## Development Facilitation Team (DFT) – Review Comments

**Project No: PR-2021-005151      Date: 07/12/2023      Agenda Item: #3 Zone Atlas Page: A-12**

**Legal Description: TRACT D-1 PLAT OF TRACTS D-1, E-1, AMAFCA BLACK ARROYO CHANNEL ROW PARADISE HEIGHTS**

### **Application For: SD-2023-00124-PRELIMINARY PLAT (DHO)**

**ISSUED FOR DHO - NOT FOR CONSTRUCTION**

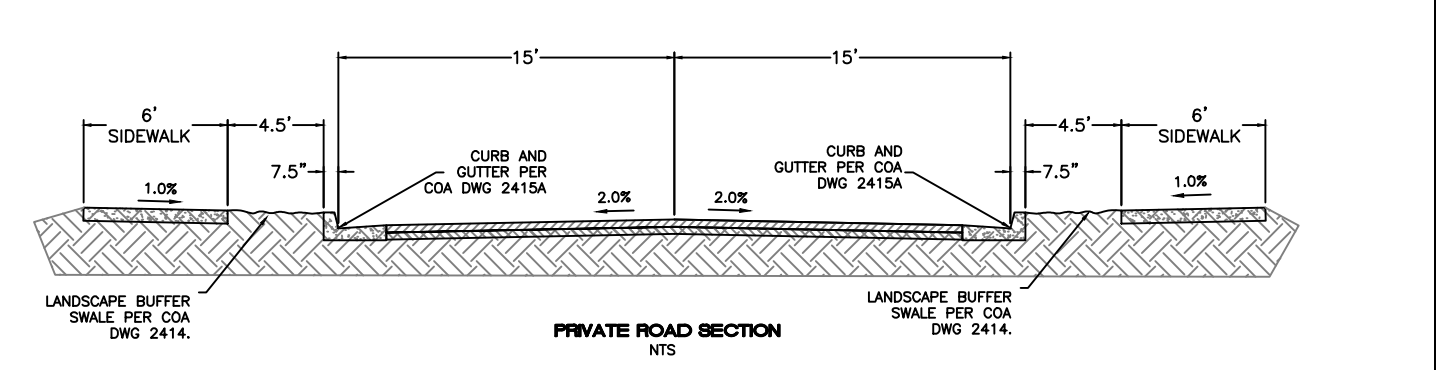
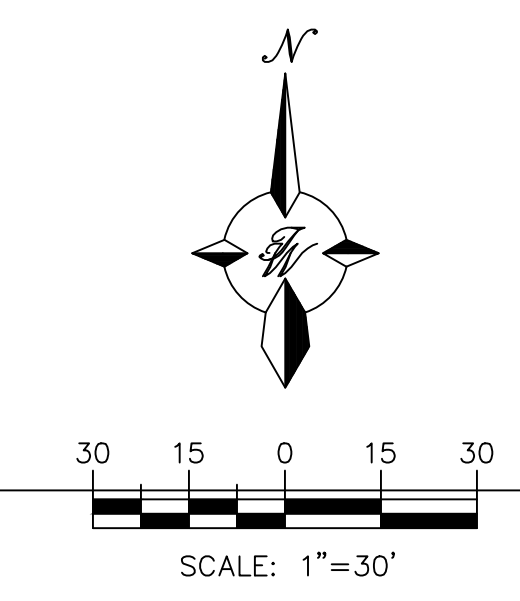
- This request is a subdivision of an existing tract (Tract D-1) into four lots which are proposed to be occupied by future commercial developments (per Sheet C1 of the Plat). Per 6-6(K)(1)(a) of the IDO, the inclusion of major public infrastructure on the associated Infrastructure List with this Plat required the submittal of a Major Preliminary Plat application.

- Sheet C1 of the Plat depicts future commercial development on the four proposed lots. Please confirm future development on the four proposed lots (if known).

Plat of
Tracts D-1-A, D-1-B, D-1-C and D-1-D
Paradise Heights, Unit 1
 Section 1, Township 11 North, Range 2 East, N.M.P.M.
 Albuquerque, Bernalillo County, New Mexico
 October 2022

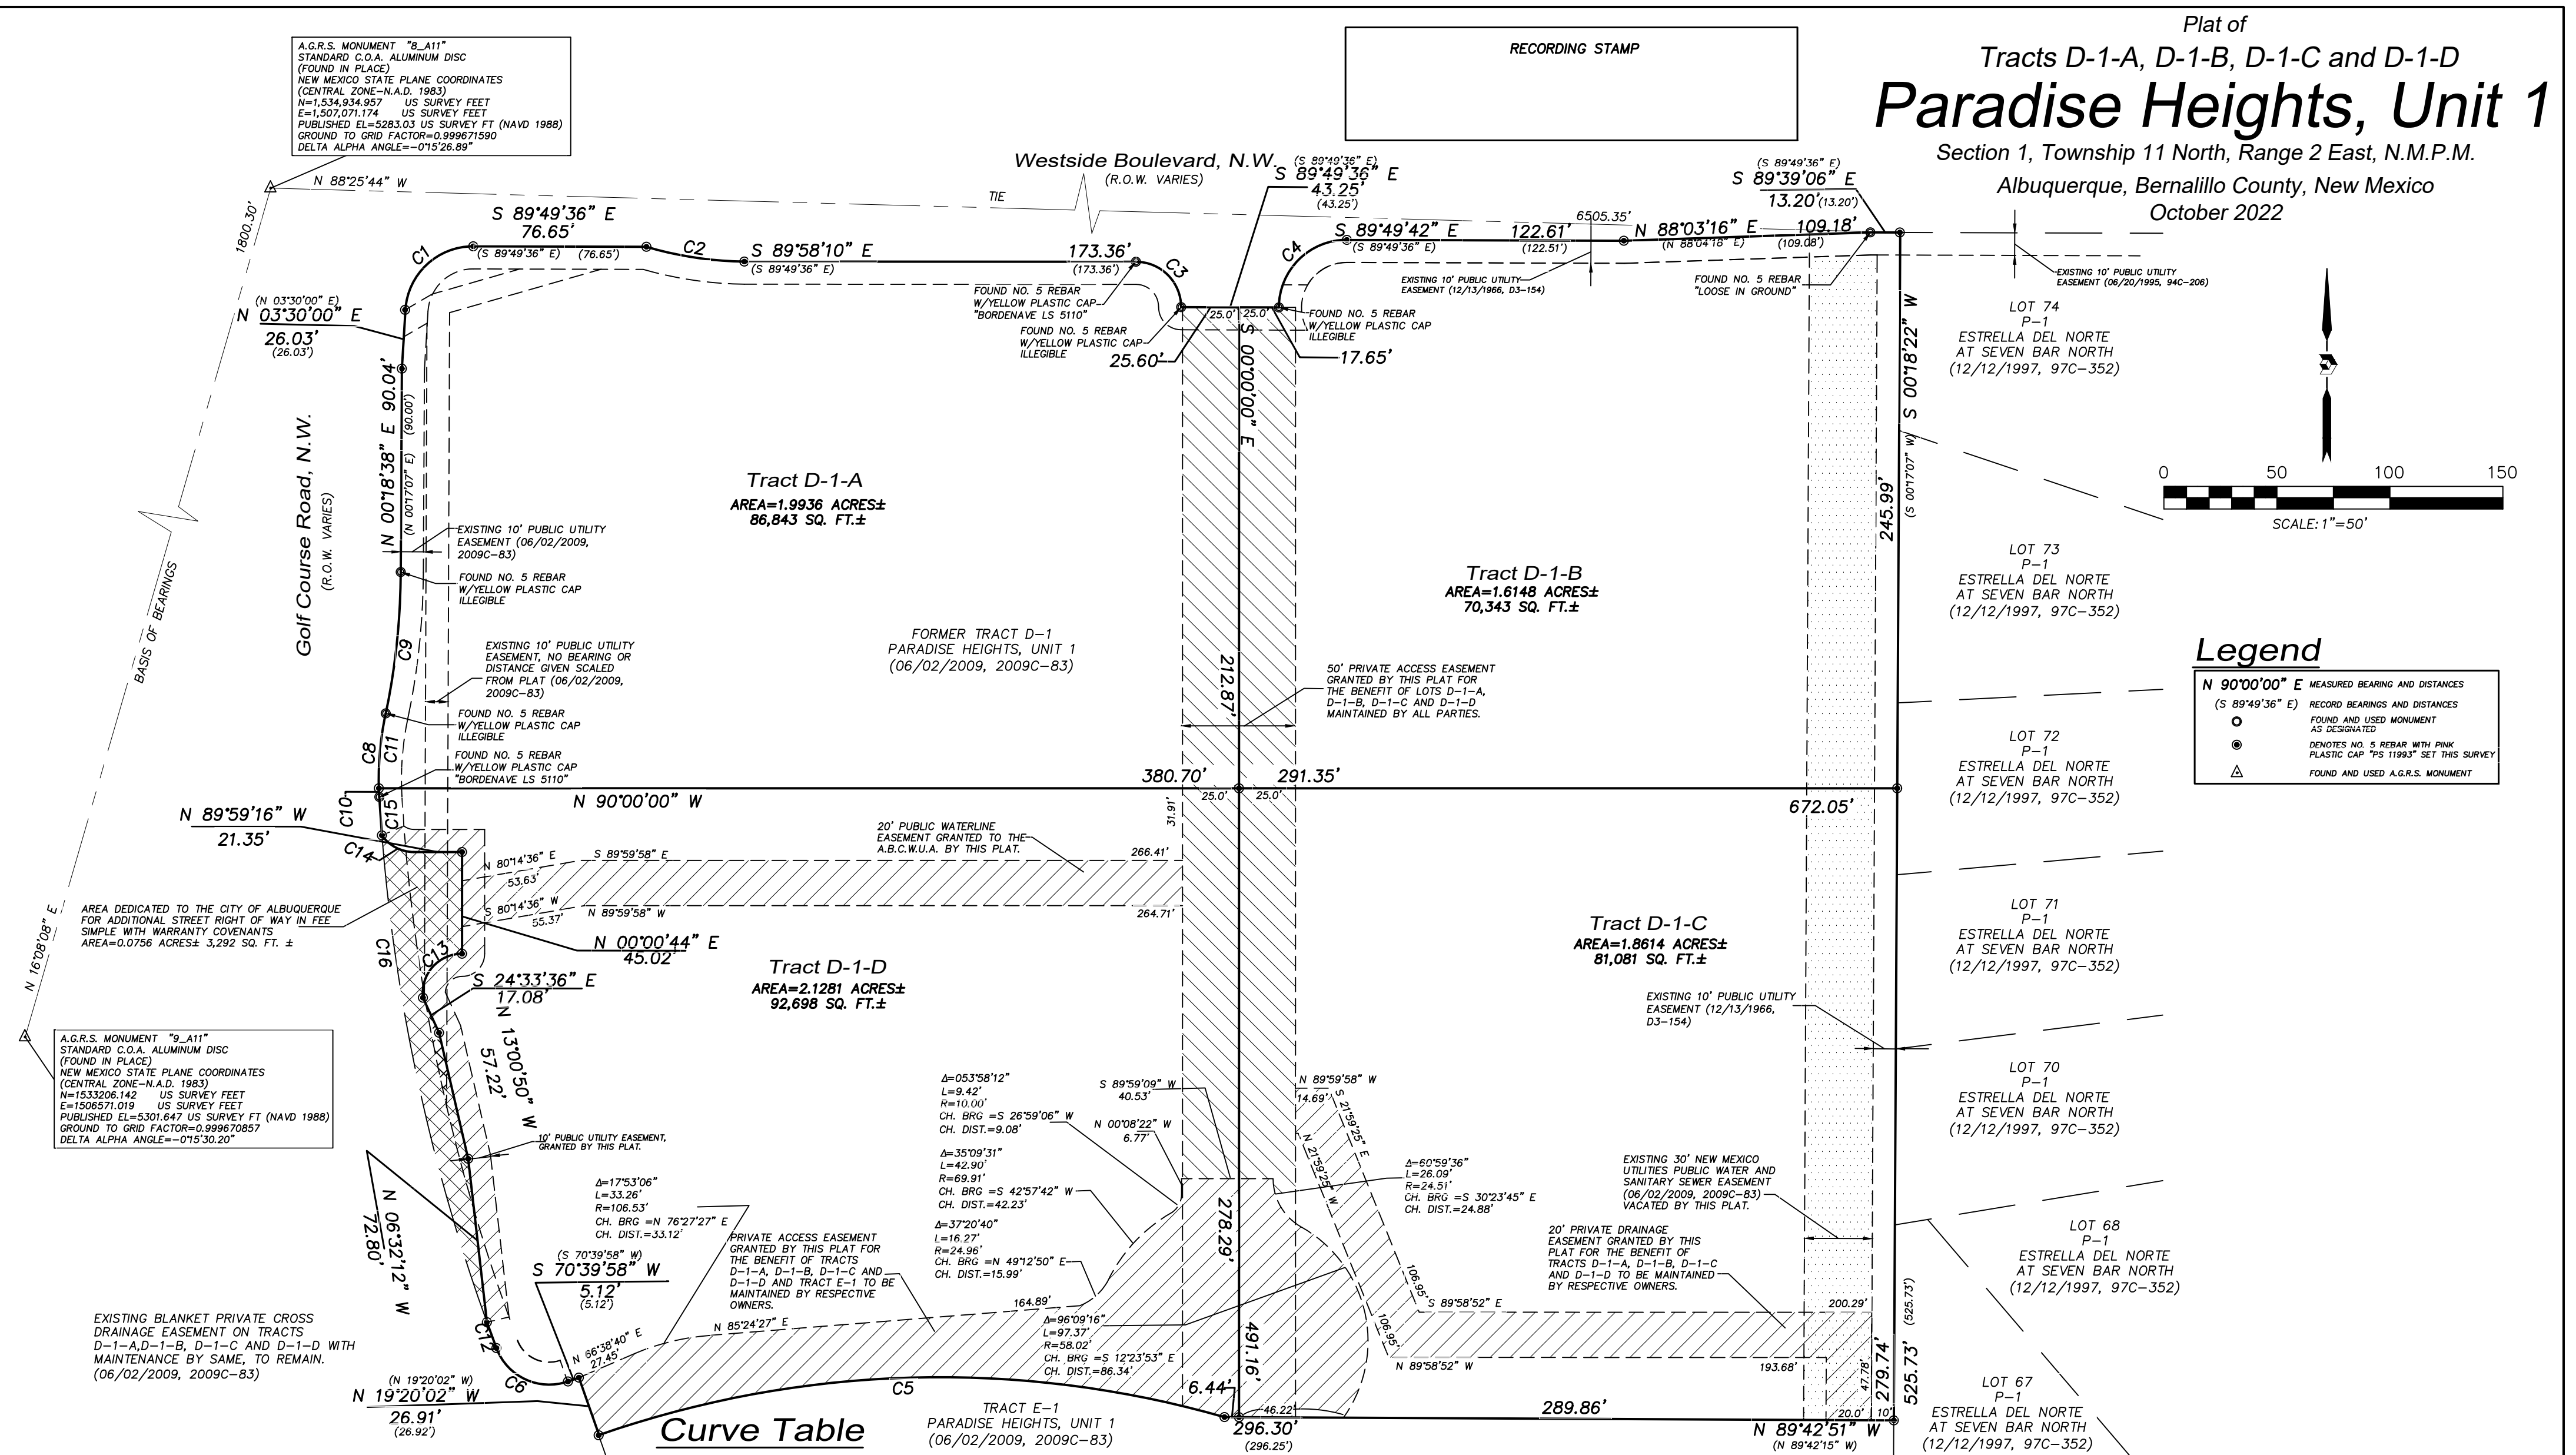
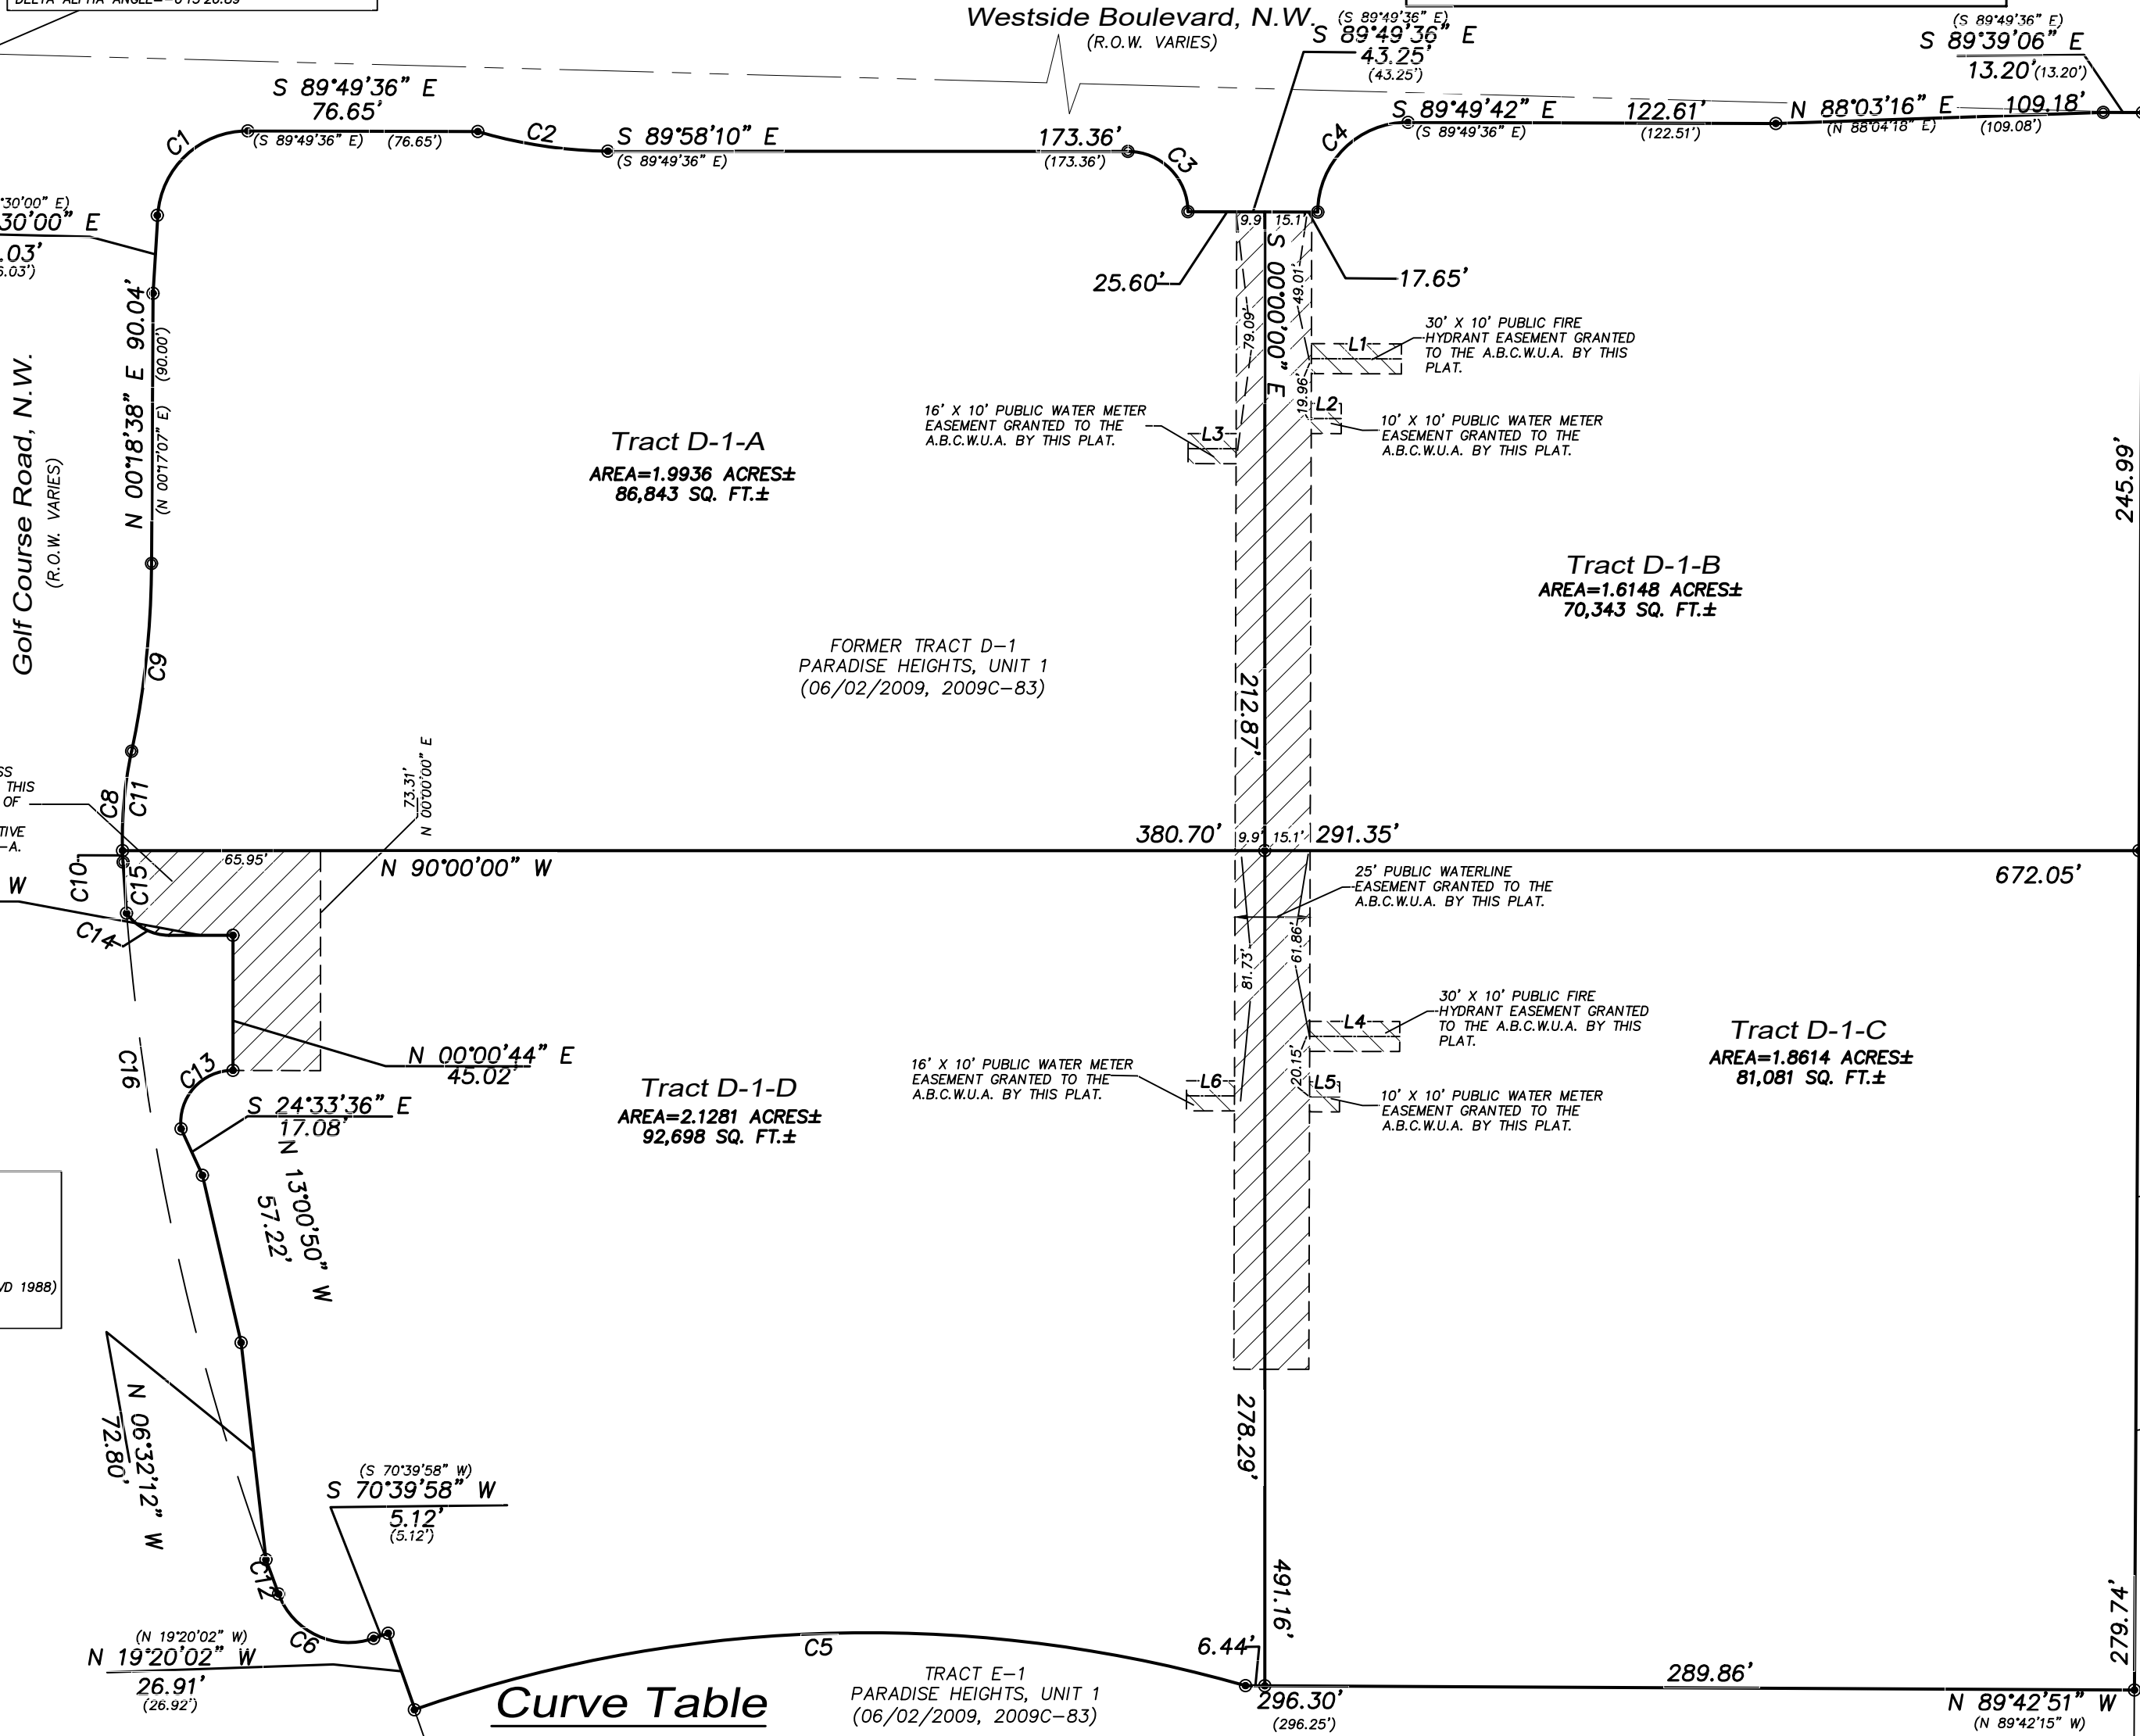
- c. For the 25' public water and public sanitary sewer easement, please clearly separate the easement as bisected by the North/South property line. The easement shows 10' on the west portion of the property line and 15' on the east portion of the property line but it should be noted that the easement is separate on respective tracts. (e.g. a 10' public water and public sanitary sewer easement and a 15' public water and public sanitary sewer easement.)
